WESTMEAD CATHOLIC COMMUNITY EDUCATION CAMPUS APPENDIX A - RESPONSE TO SUBMISSIONS AND REQUEST FOR ADDITIONAL INFORMATION AND CLARIFICATIONS

CEL & ADMIN BUILDING
WEST ELEVATION SHADOW STUDIES

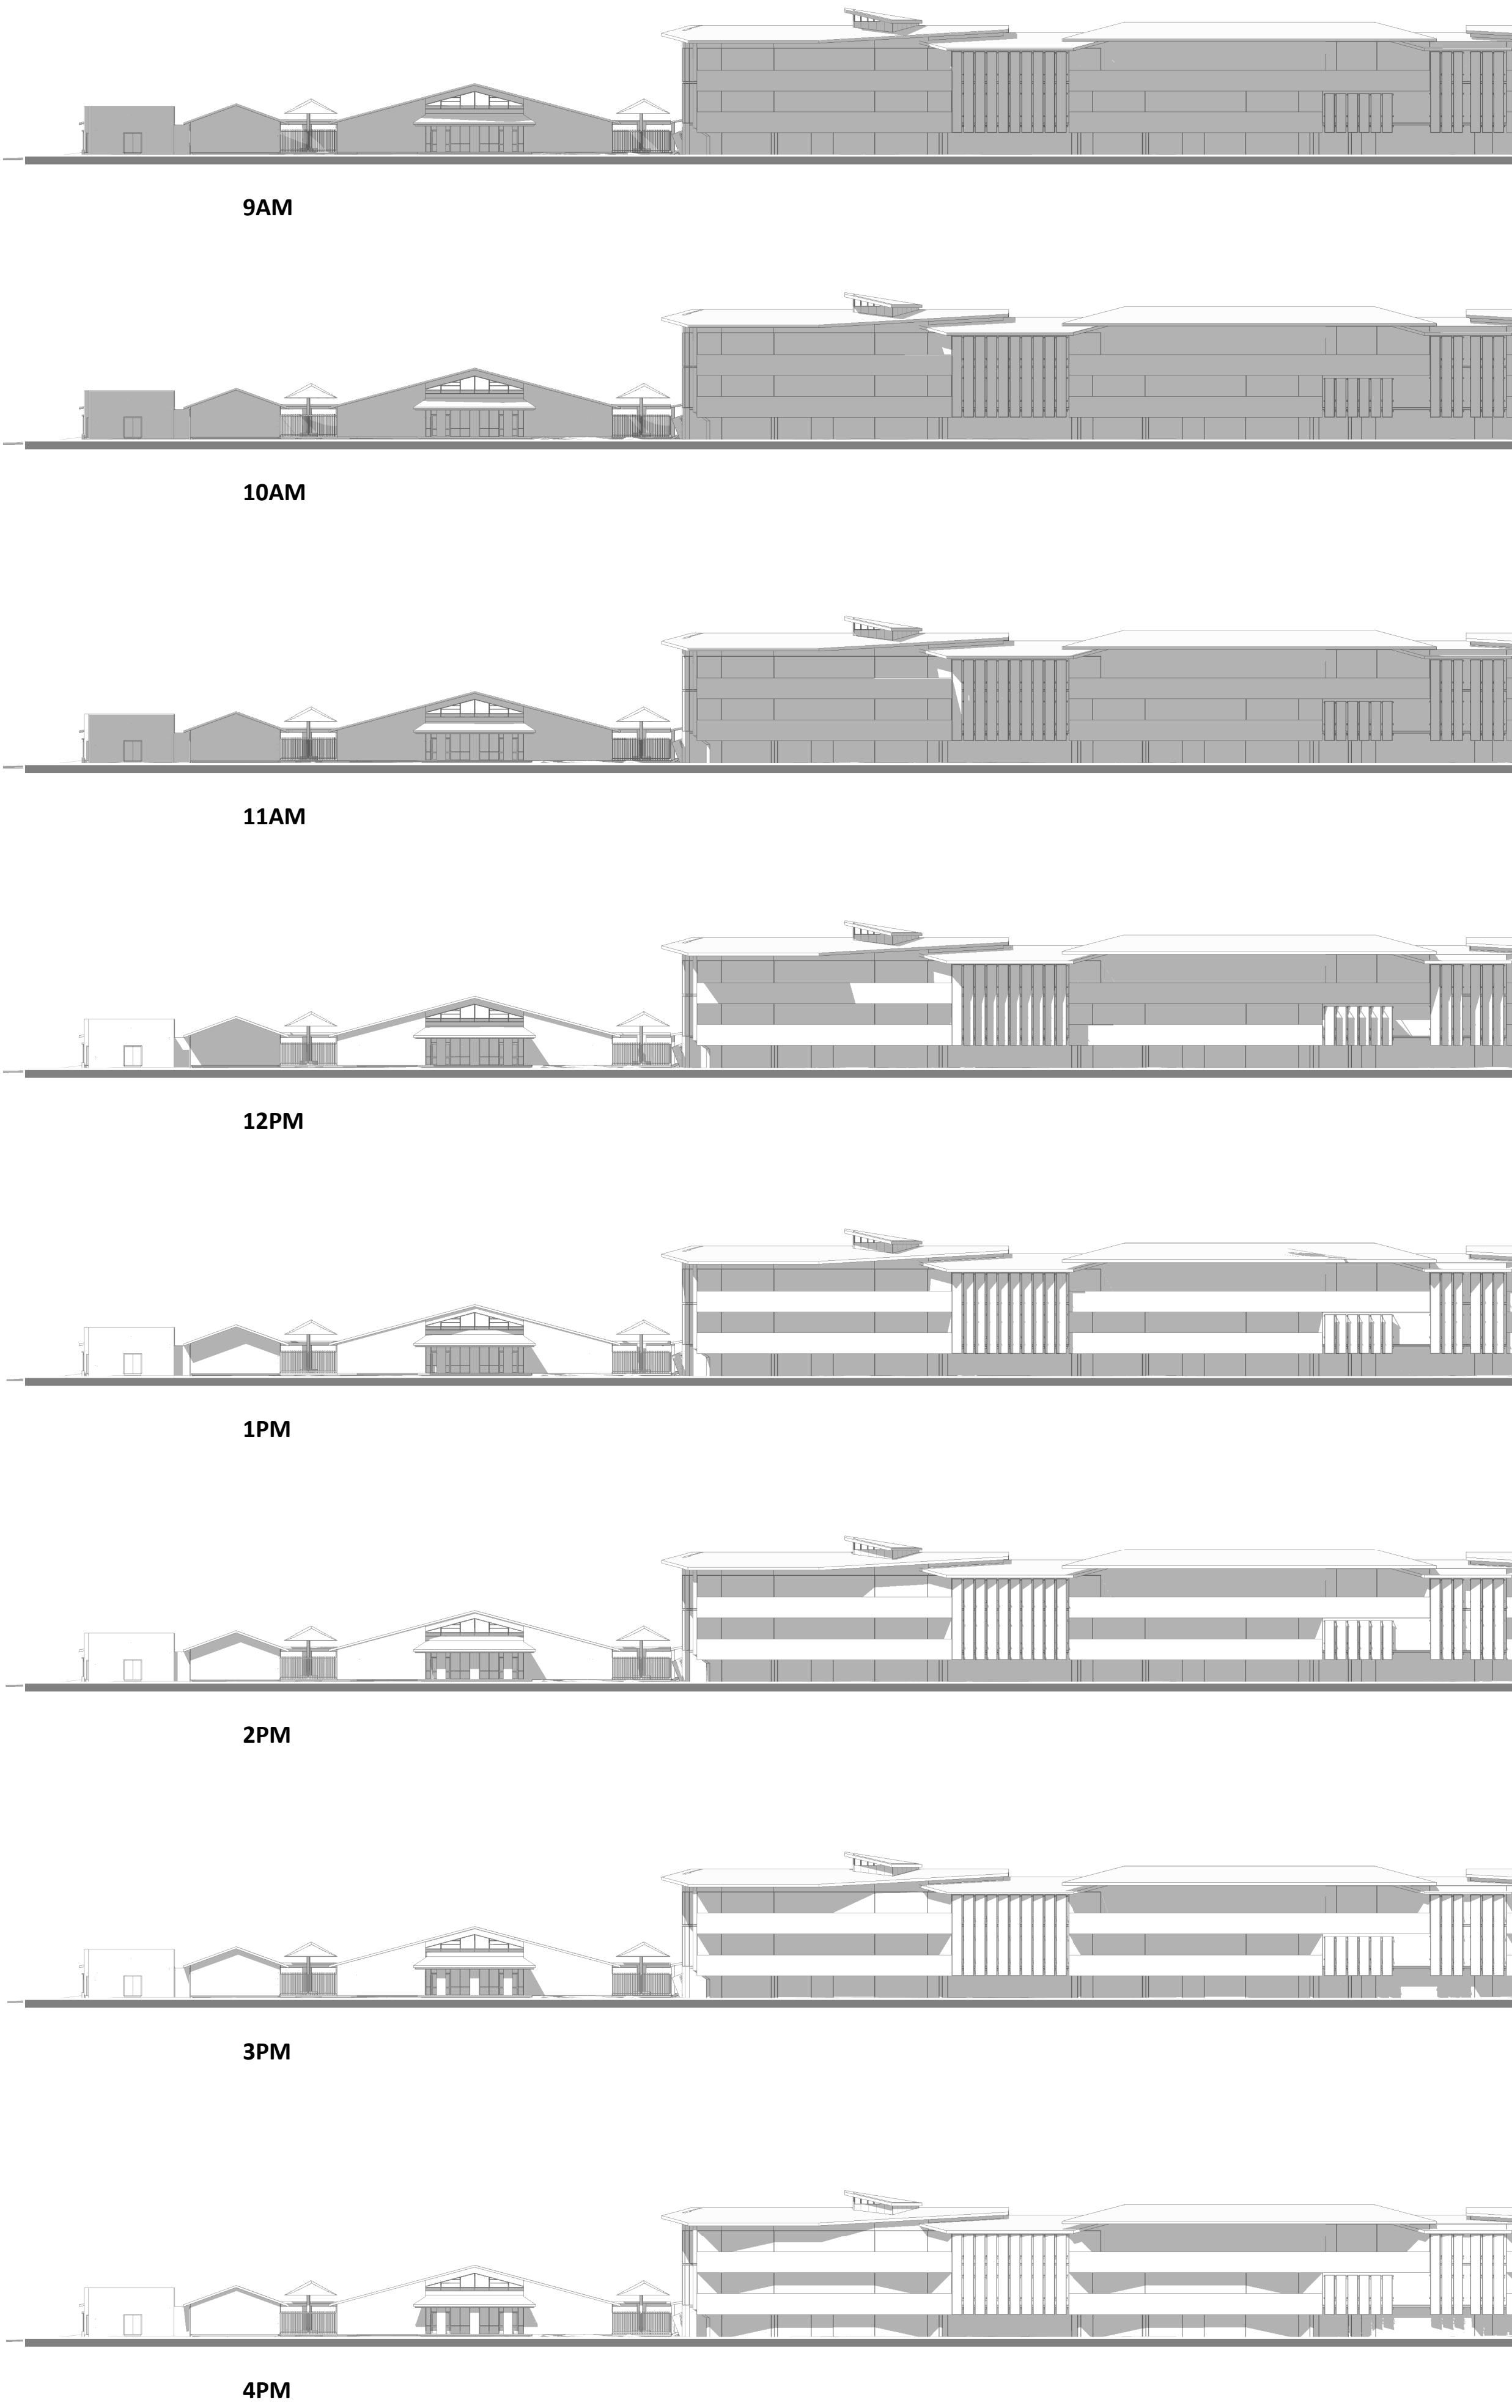
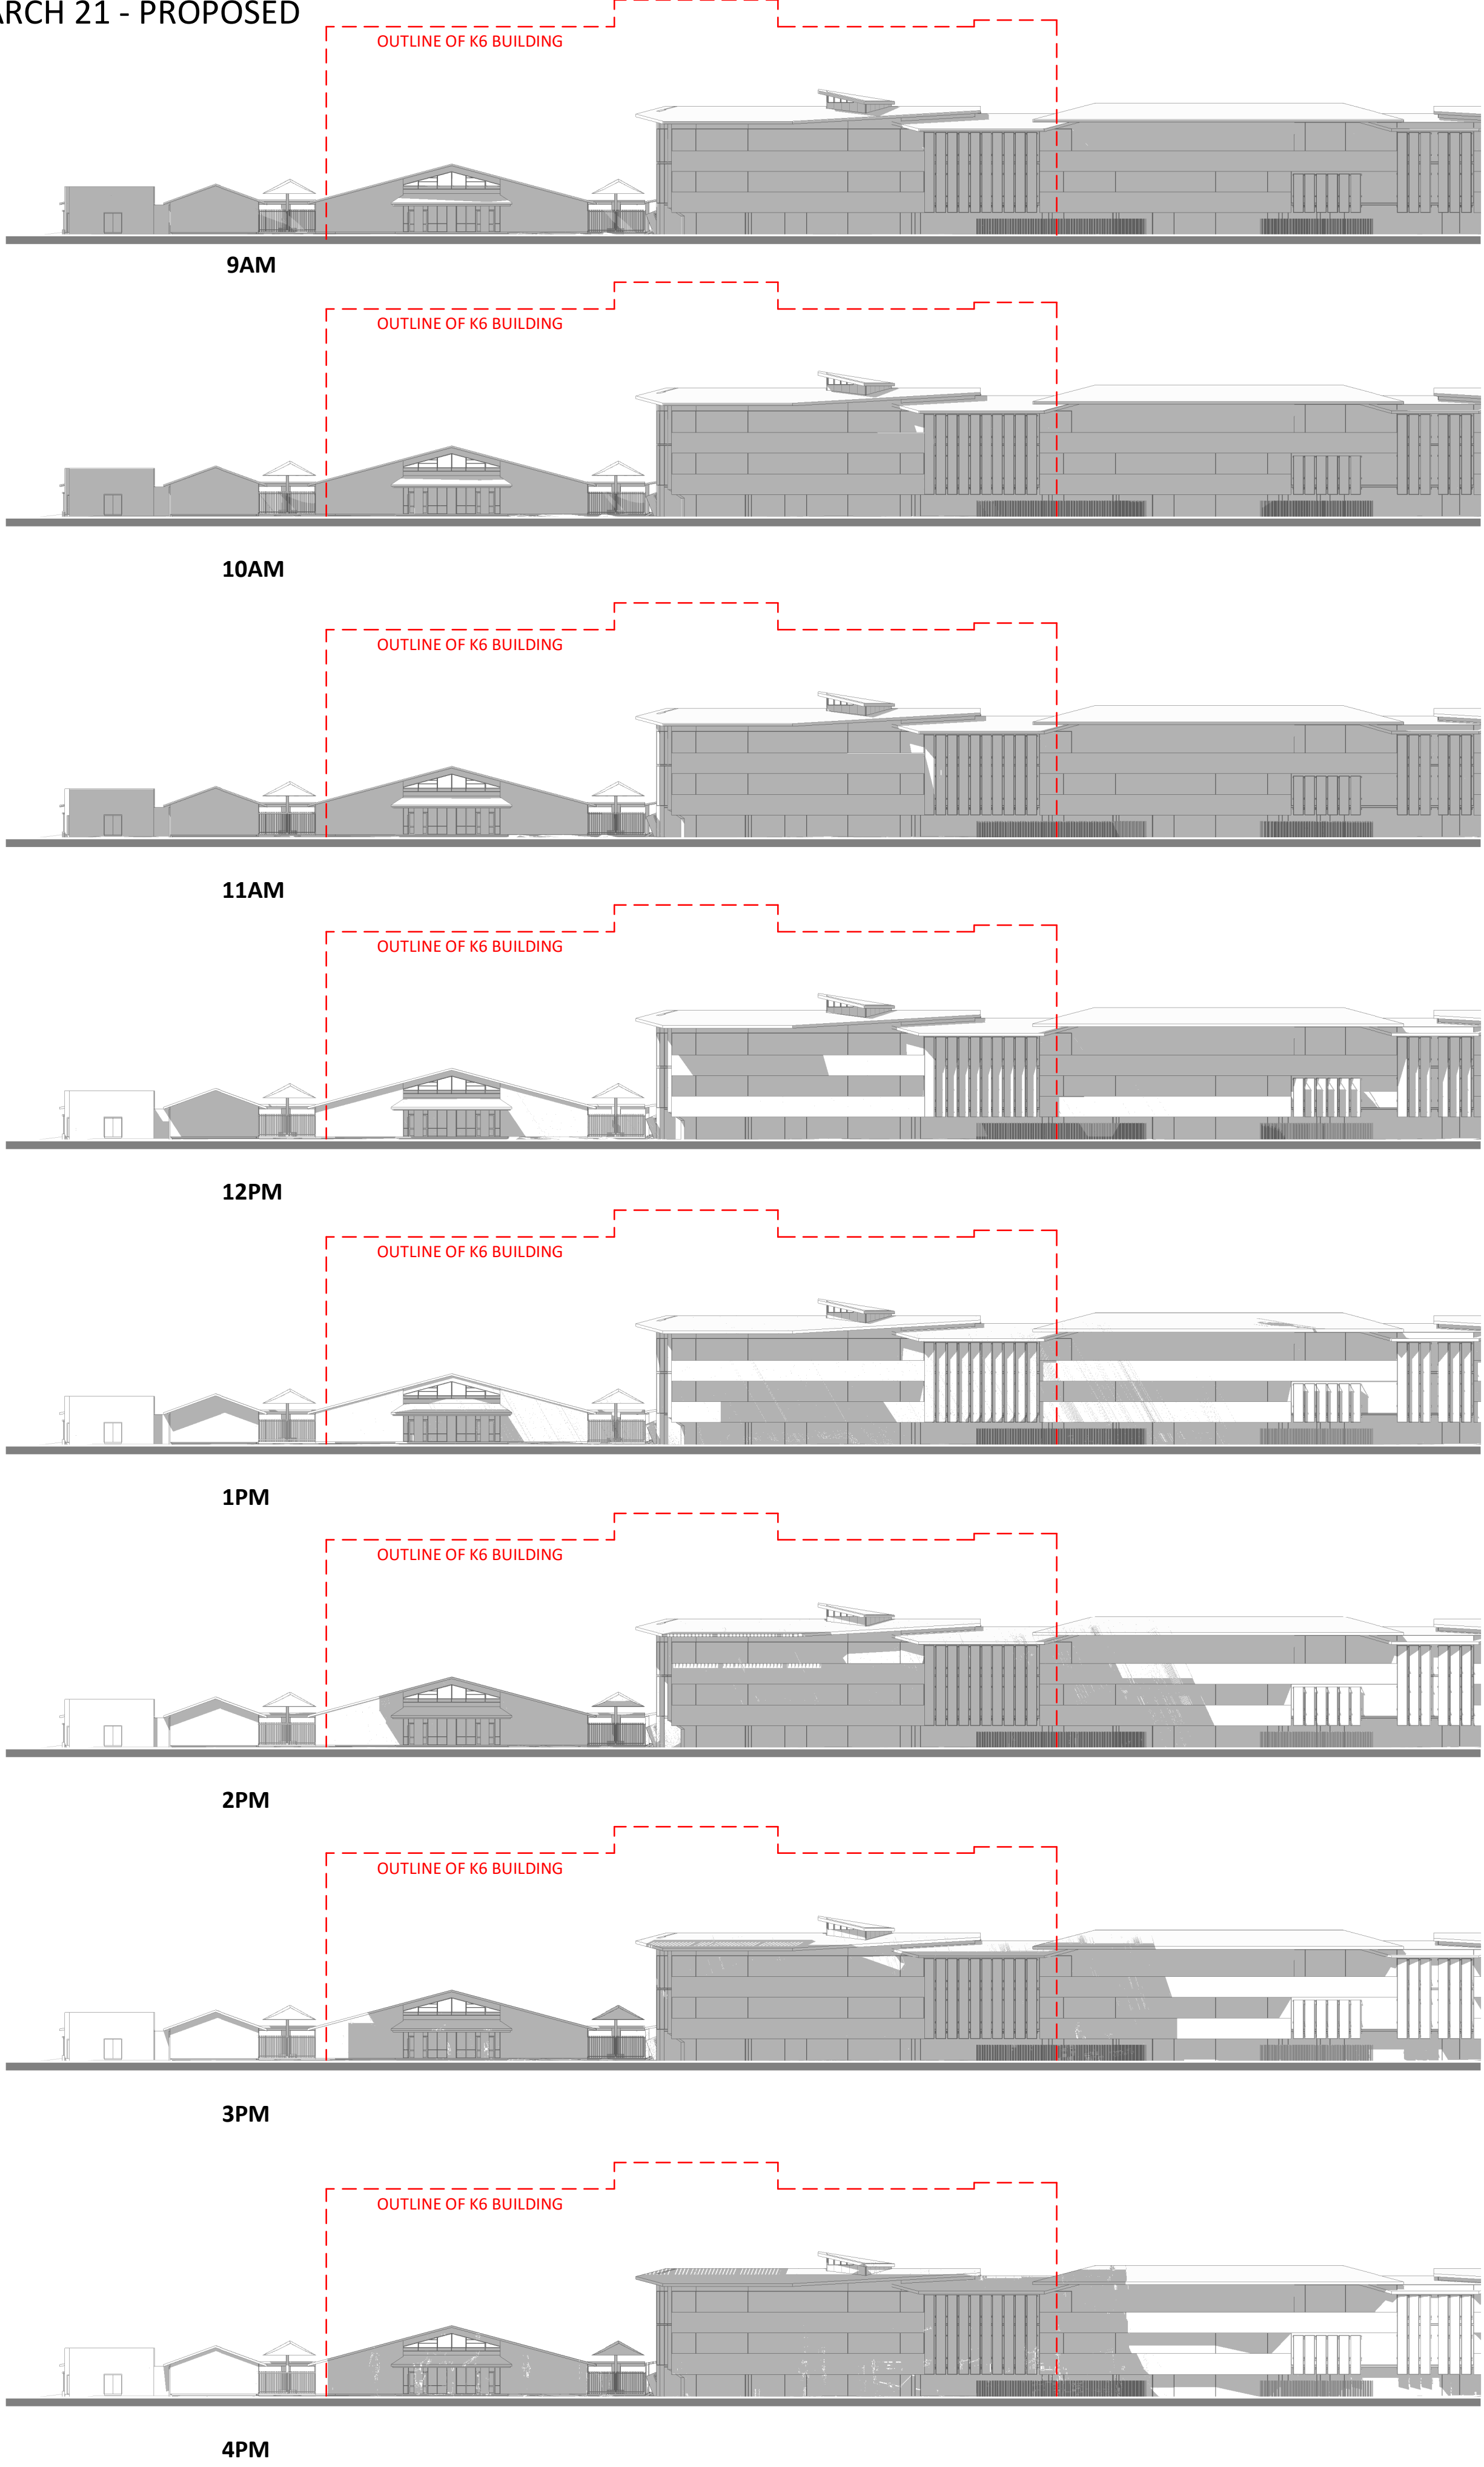
27			<p><u>Shadow diagrams</u> Hourly elevational shadow diagrams are to be provided for the proposed development during the winter solstice to assess the impacts of the primary school building on the façade of the childcare centre / administrative building.</p>	<p>Additional Shadow Diagrams have been prepared and are provided at Appendix B.</p> <p>The diagrams show that on the winter solstice, shadow impacts will be unchanged in the morning period. After midday, the proposed building will cause additional overshadowing of the CELC building.</p>

Item No	Name	Type	Issue	Response
				On the equinox, shadow impacts are largely unchanged until approximately 1pm. After 1pm, the proposed building will cause additional overshadowing of the CELC building. Whilst there be some additional overshadowing, this will not have a significant impact on the use of the existing building.
28			<u>Plans</u> The Submitted architectural plans do not clearly differentiate which parts of the ground floor of the primary school is covered and are within the building envelope. Therefore, revised architectural plans are to be submitted to clarify this.	This detail is shown on the revised Architectural Drawings at Appendix B .
29			The revised plans must include the outline of the roof over each floor to identify the covered open space area on each level.	This detail is shown on the revised Architectural Drawings at Appendix B .
30			<u>Photomontage</u> Photomontage of the proposed buildings in relation to the existing buildings on site, (preferably from various angles to cover all the buildings on site) should be submitted so that the relationship of the proposed development and the existing developments on the site can be assessed in detail.	Additional photomontages have been provided at Appendix I .
